Application No: BN/7/22/HH
Site Address: 10 Downview Road Barnham PO22 0EE
Description of works: Erection of outbuilding to rear.

Thank you for your internet representation made on 16th March 2022 which has been recorded as no objection with the comments as follows:

PROPOSED FRONT ELEVATION
(scale 1:50)

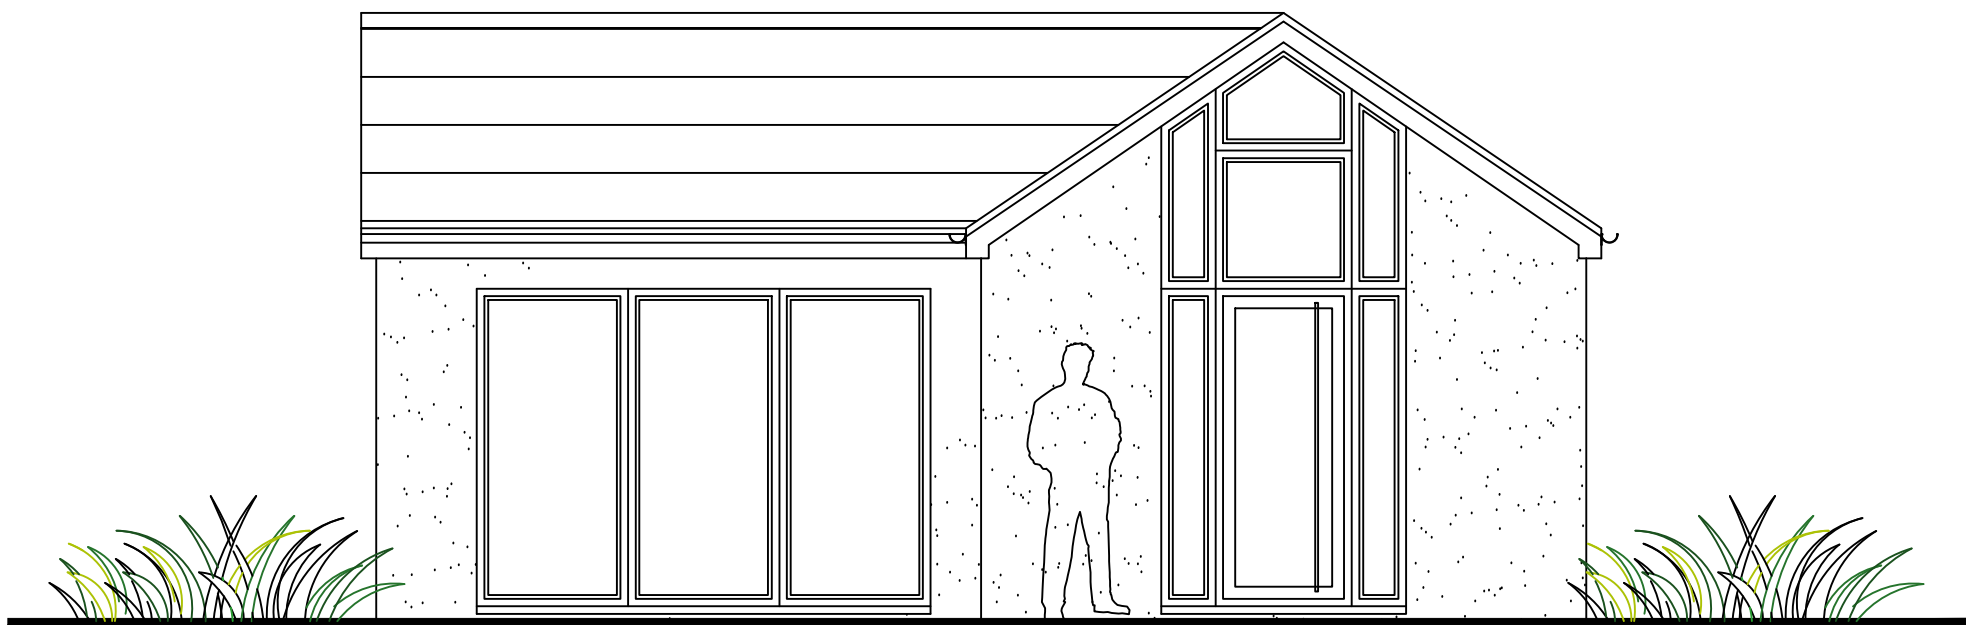
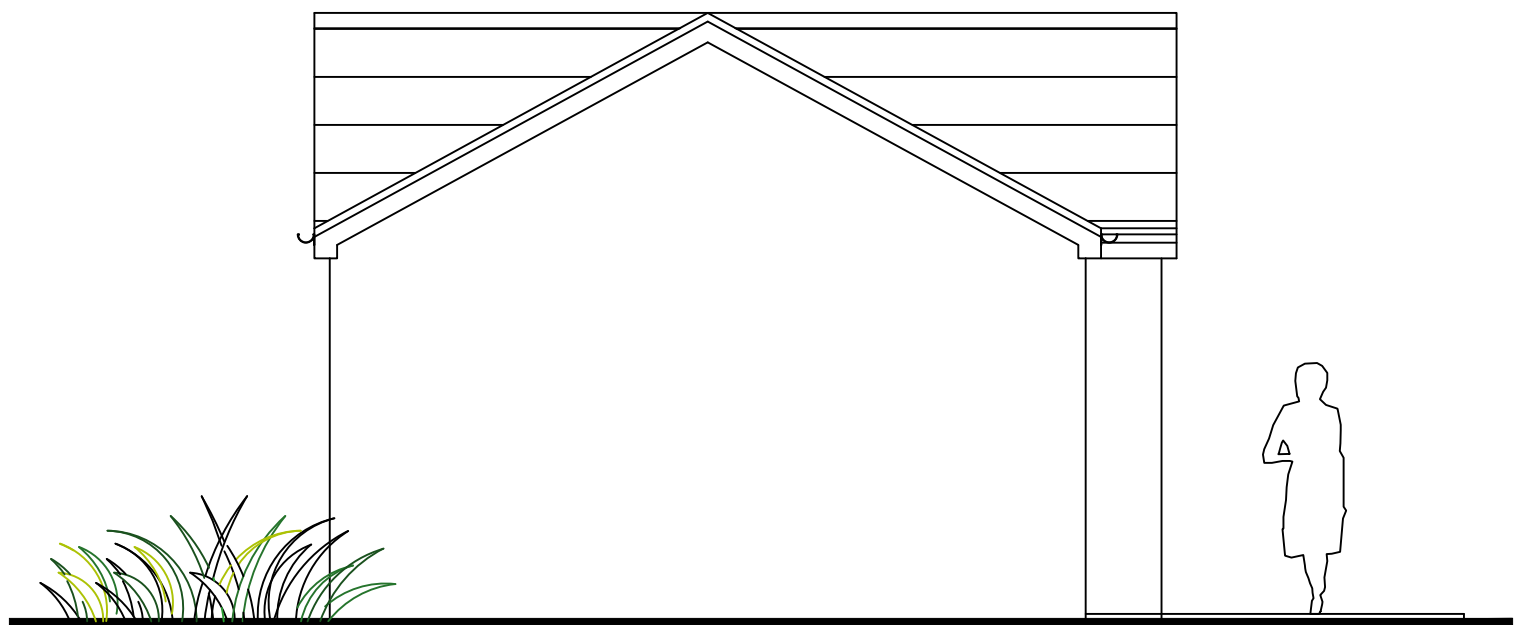
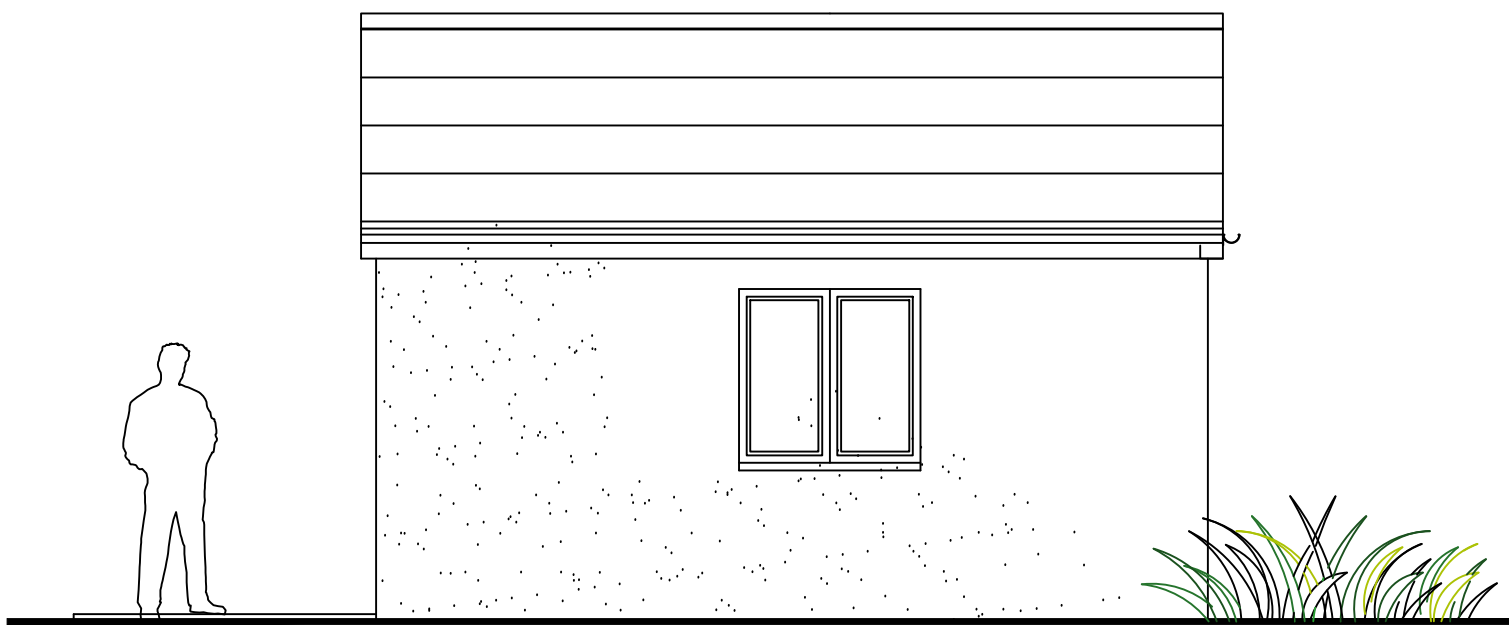
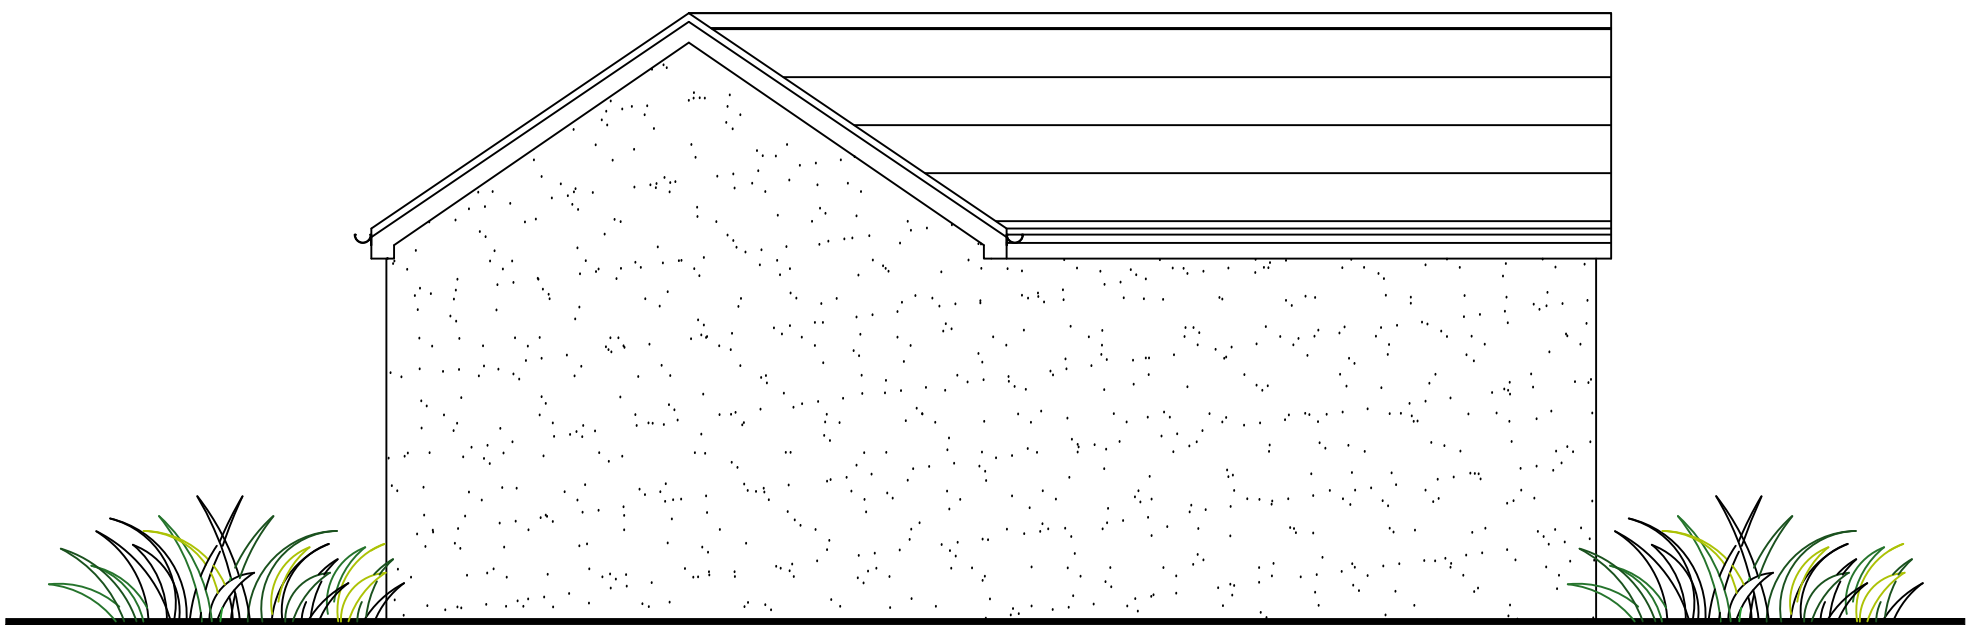
Is this a standard height for a single storey "gym/playroom"?

Will it be soundproofed? With my house and in particular, a bedroom directly opposite, it would be useful to know.
